A47 North Tuddenham to Easton

Scheme Number: TR010038

Volume 9 **9.27 Applicant's Responses to Deadline 6** **Comments**

January 2022

## APPENDIX B. ALTERNATIVE OPTION DEPARTURES

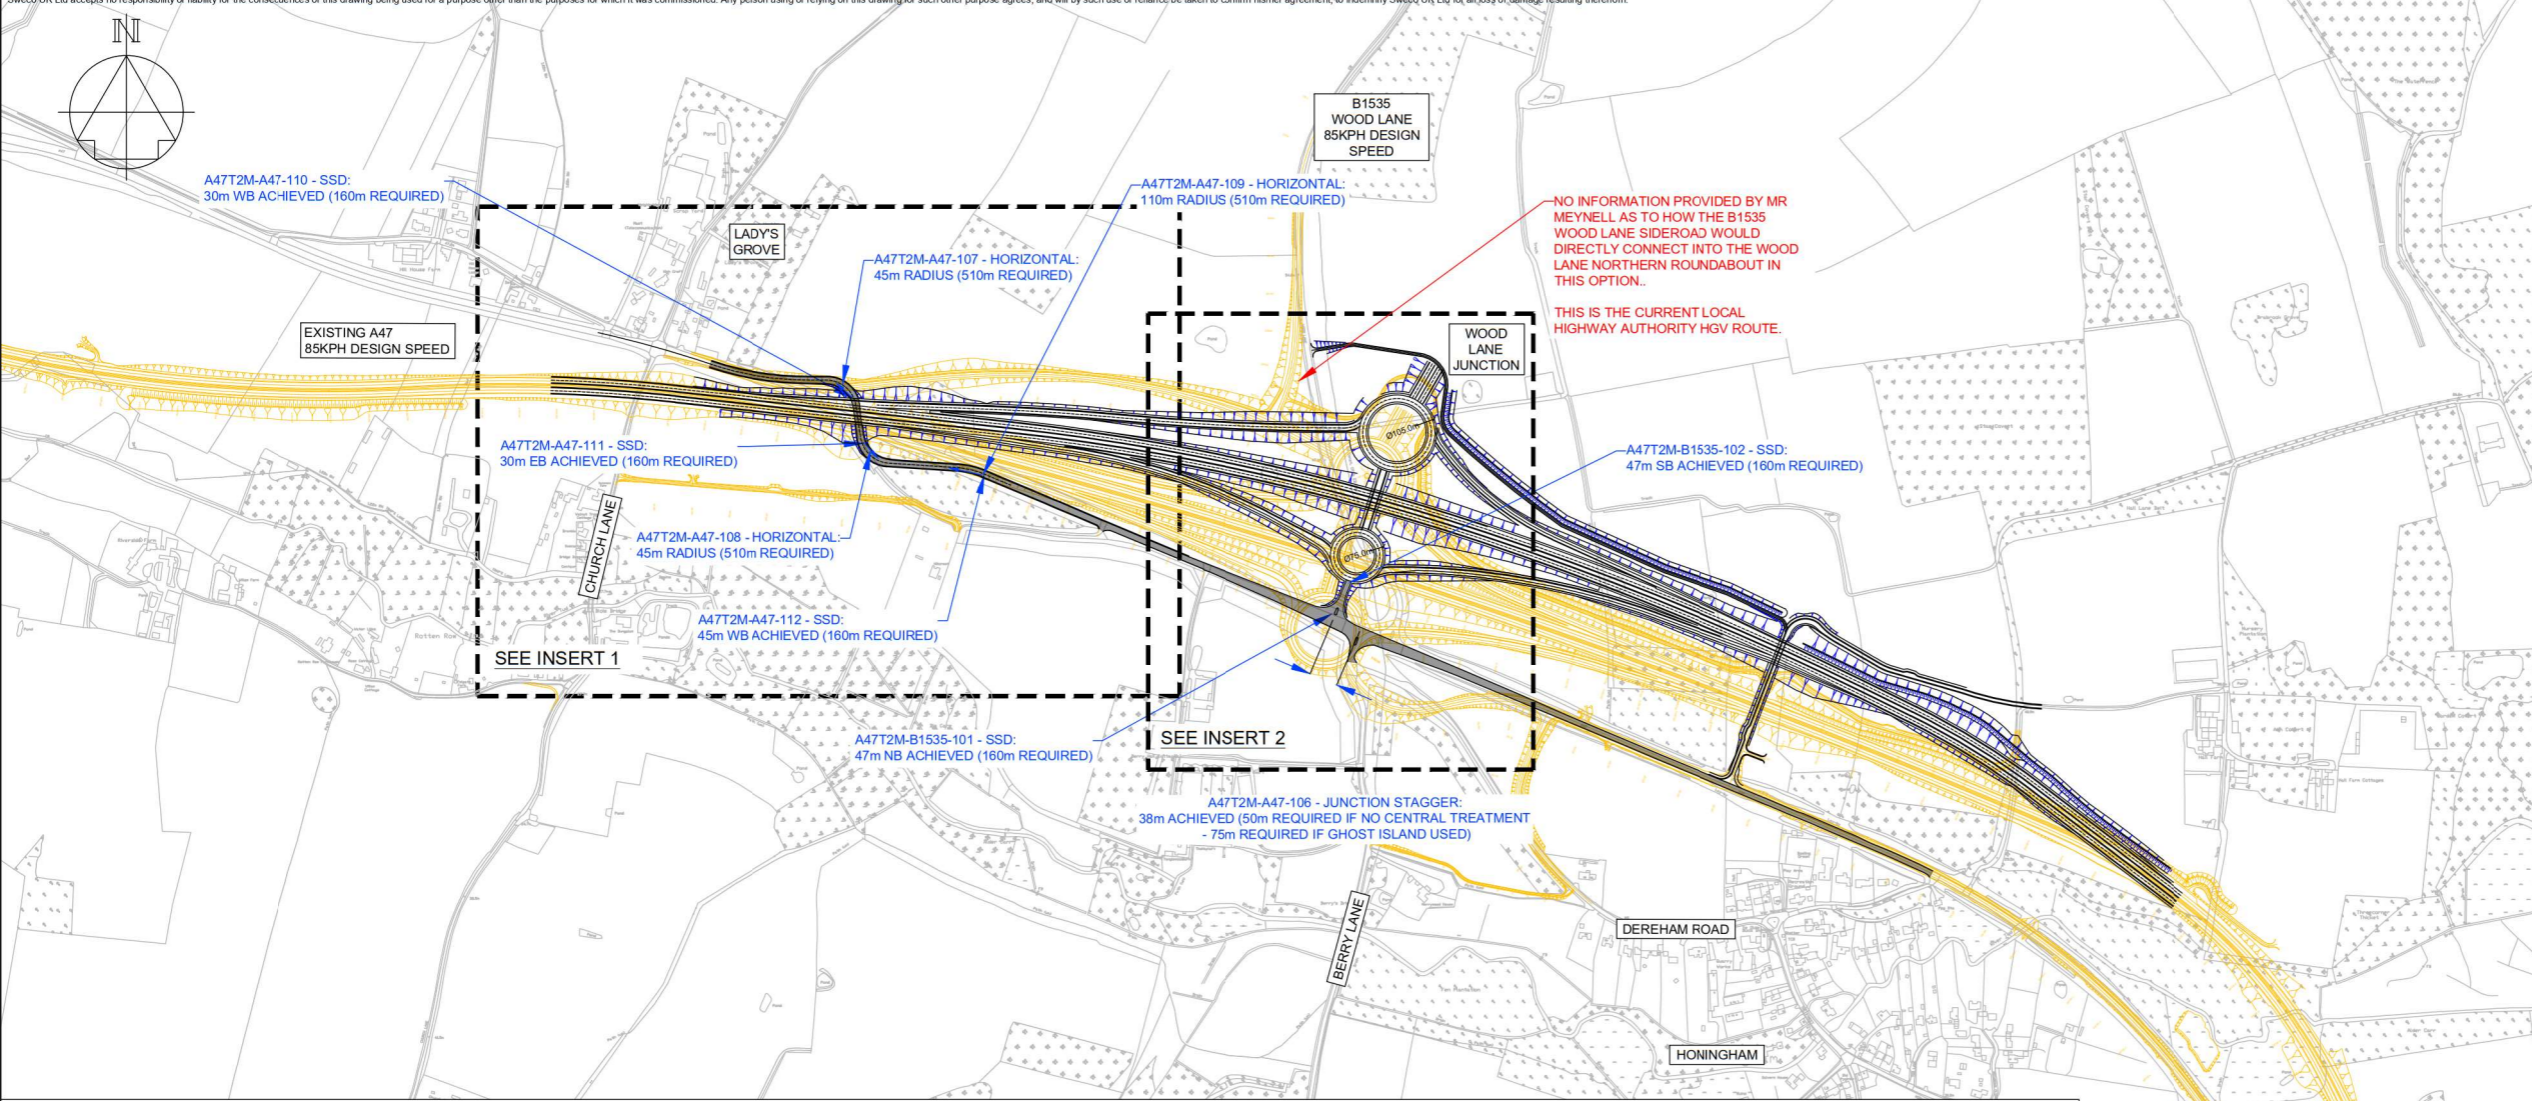
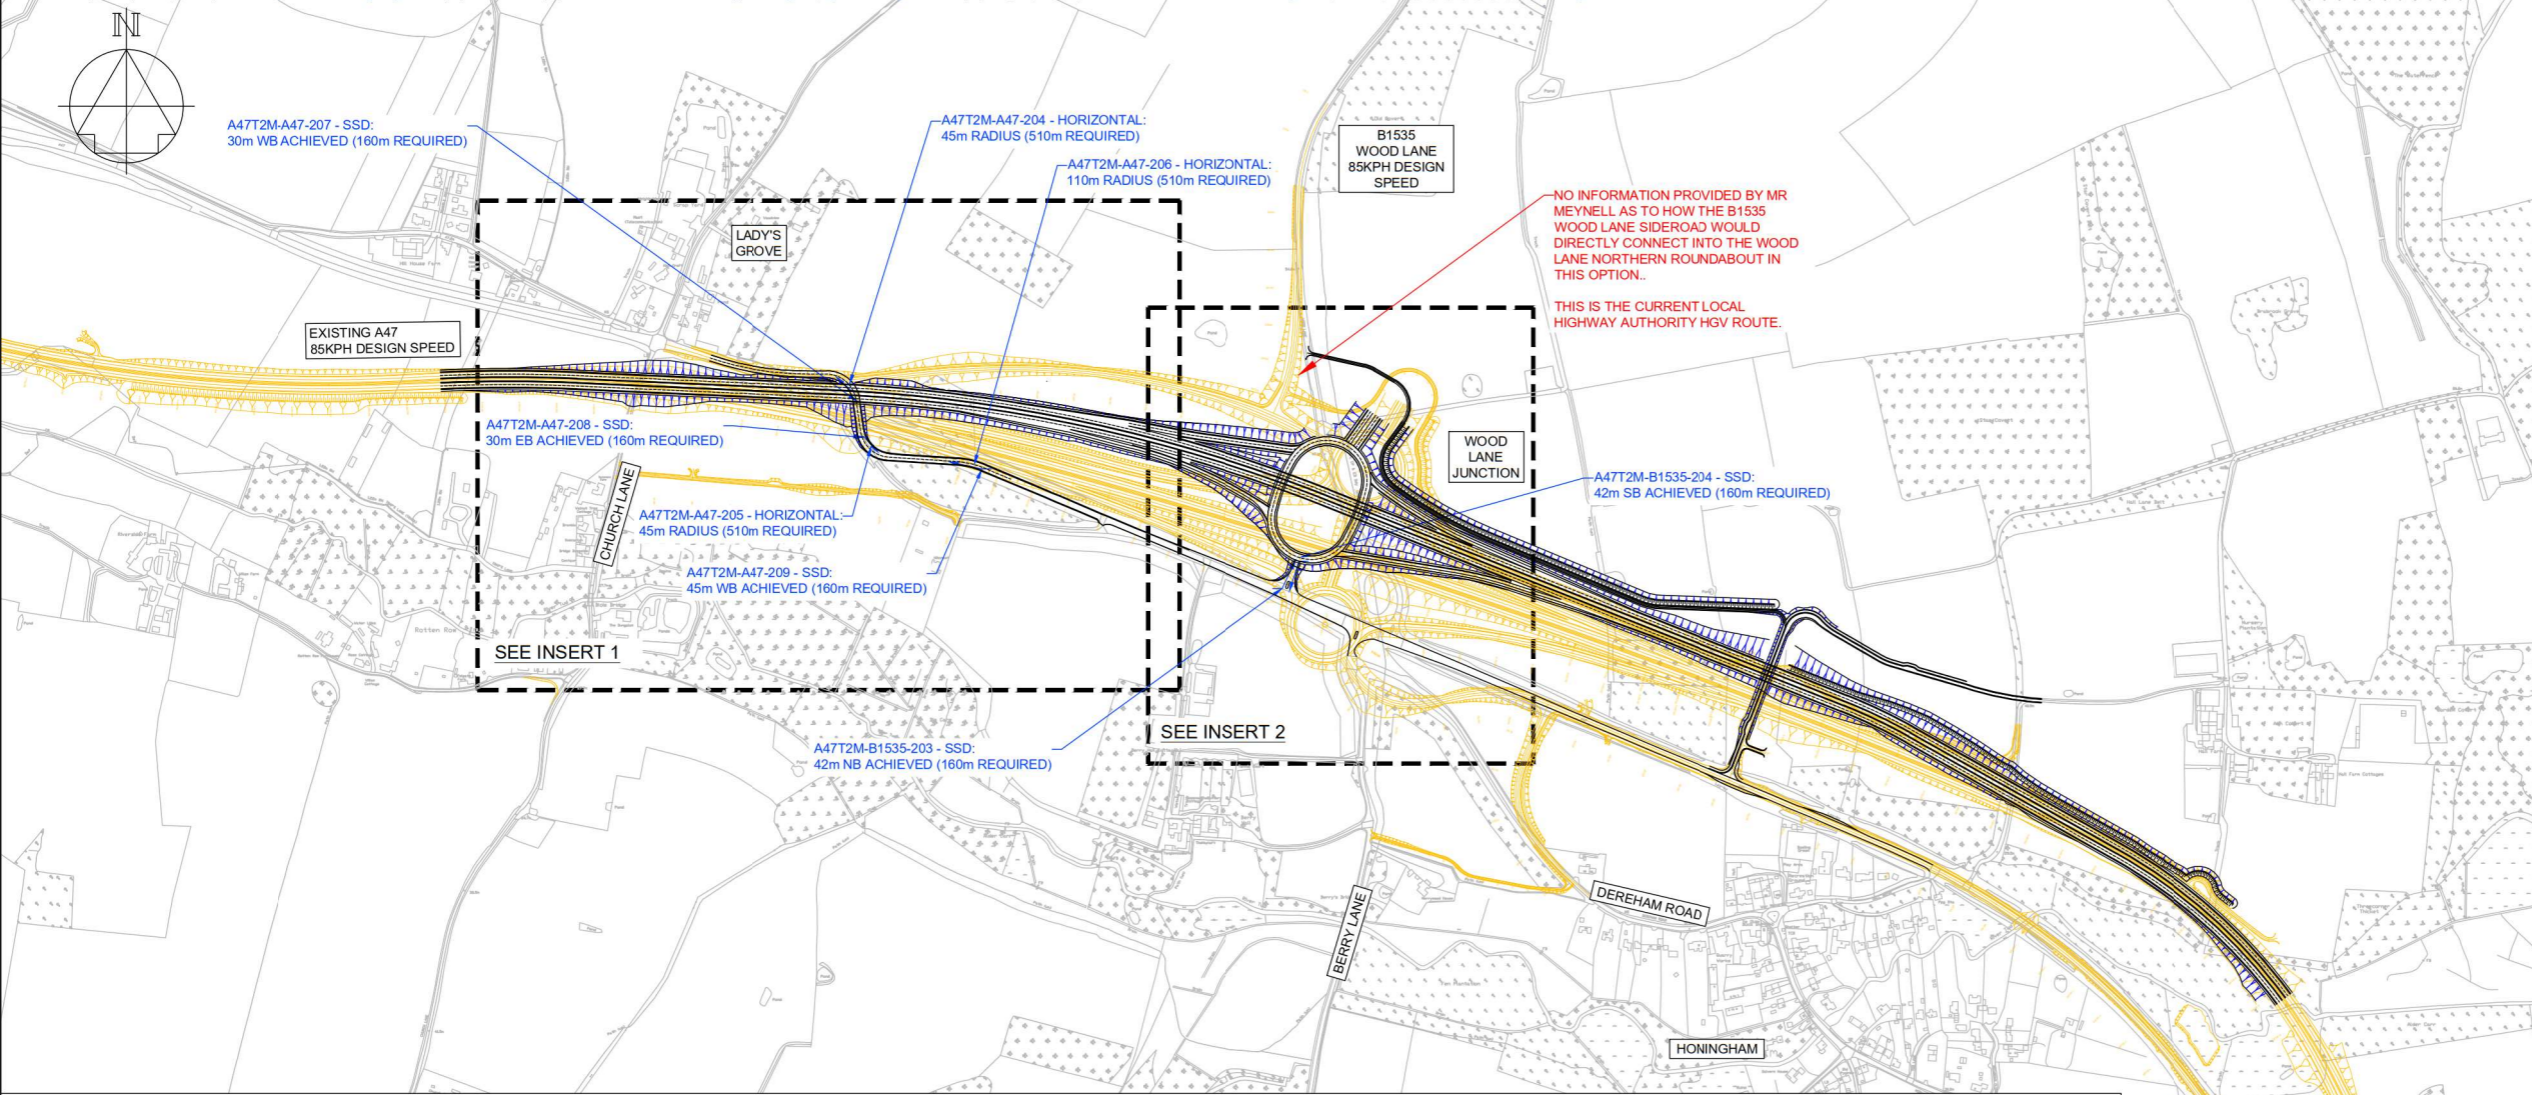
| Comment | Applicant Response |
|--|--|
| <p>ACM claims a reasonable alternative scheme design with a number of different options for it, remains fully capable of avoiding adverse impact on the cultural heritage interests and preserving the integrity of the [REDACTED] these or any other options to adjust the location of the junction and its associated roads and structures to reduce the effects on the Estate, have not so far been adopted.</p> | <p>The Applicant has undertaken an assessment of the alternative Wood Lane junction options, as reported in the updated '9.15 - Alternative Wood Lane Junction Options Appraisal' (REP6-015) issued at Deadline 6.</p> <p>The analysis demonstrates that each of the alternative options proposed has significant deficiencies across a range of key criteria where assessments were possible. It follows that the current Scheme design remains the preferred Wood Lane junction design option with regards location and layout to be taken forward as the most appropriate solution in the location.</p> <p>This conclusion is supported by Norfolk County Council in their Deadline 6 Submission 'Comments on any additional information/submissions received by D5' which also states "...the County Council can confirm that it supports the Applicant's proposal for this junction."</p> <p>The provision of Wood Lane junction has also been supported by the relevant district councils since statutory consultation, as reflected in the below Examination submissions at Deadline 4:</p> <ul style="list-style-type: none"> • Statement of Common Ground with Breckland Council (REP4-004) • Statement of Common Ground with Broadland District Council (REP4-005) • Statement of Common Ground with South Norfolk Council (REP4-006) |

| Comment | Applicant Response |
|---|--|
| <p><i>Regarding Applicant's Response at Deadline 5 - REP5-016, Applicant's Appraisal of Alternatives (AS-022) and REP4-016 size of Wood Lane junction.</i></p> <p>The original Appraisal was responded to on behalf of ACM at REP4-023 Appendix A (Technical Note by Mr Joe Ellis). The updated version of the Appraisal was not submitted by the Applicant at Deadline 5 and will be responded to by ACM when received.</p> <p>REP4-016 did not provide evidence, only an unsupported statement.</p> <p>ACM has asked the Applicant to provide cross sections of the Wood Lane junction in order to be able to understand more clearly the effect its south side as proposed on the BHE and Honingham village and these should be provided also to Honingham PC.</p> | <p>The Applicant has undertaken an assessment of the alternative Wood Lane junction options, as reported in the updated '9.15 - Alternative Wood Lane Junction Options Appraisal' (REP6-015) issued at Deadline 6.</p> <p>The Wood Lane junction long sections, showing how the Scheme landscaping will screen the [REDACTED] are provided in Appendix A of the Applicant's Response to Examining Authority's Third Written Questions (REP6-018) issued at Deadline 6. These have also been issued directly to Mr Meynell. Updated cross sections have also been issued as Appendix A to the Applicant's Written Summary of Oral Submissions at ISH3 (TR010038/EXAM/9.29) submitted at Deadline 7.</p> |
